Re: **RDU2407807 - Revision #1**
Date: 08/01/24
Location: 121 Ithaca Ln. (121 Ithaca Ln, Bunnlevel, NC)
JDS Project No.: RDU2407807
Date of Inspection: 07/31/24

A representative of JDS Consulting arrived on site to observe the issues reported to us by the client, which are presented, along with our recommendations, in this report.

FRONT ELEVATION
9' CEILING HEIGHT

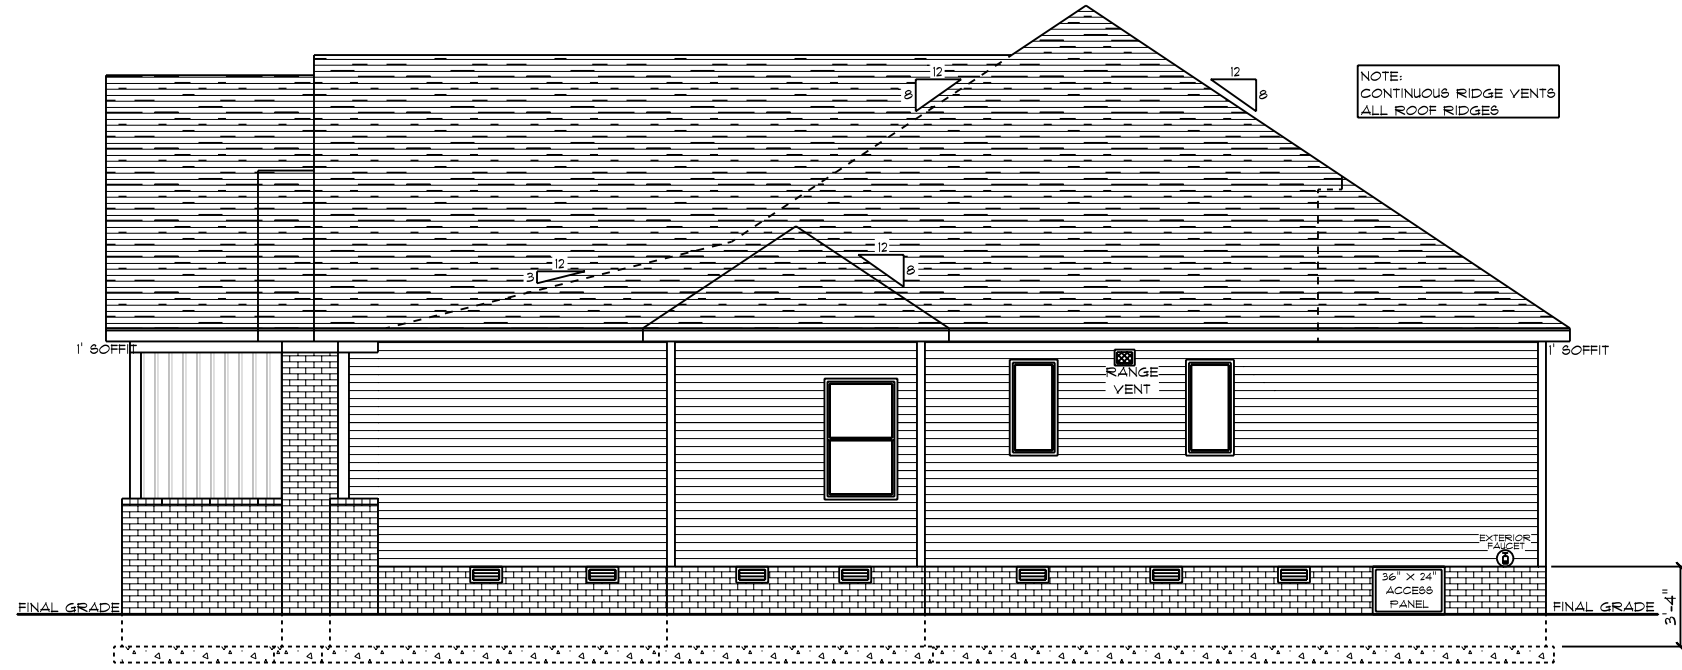
1. The (3) roof trusses above the front porch window have been trimmed to sit flush with the wall. The contractor has installed 2x4 bearing blocks on both sides of each modified truss.
2. The inspector is questioning the R05 roof truss hanger at the front wall. The hanger is nailed into the girder truss but also a 2x4 that doesn't have full bearing atop the girder truss.

1. The modifications to the trusses and the addition of the 2x4 blocking is adequate for the loading conditions. Ensure that each bearing block is nailed with (2) rows of 10D nails spaced at 4" o.c.
2. Tightly install a full length osb strip between the girder truss and the flat 2x4 above that the hanger is attached to. Ensure that the 2x4 is attached through the OSB shims with (2) rows of 10D nails spaced at 4" on center. Stagger nails as needed and nail into the center of the plys.
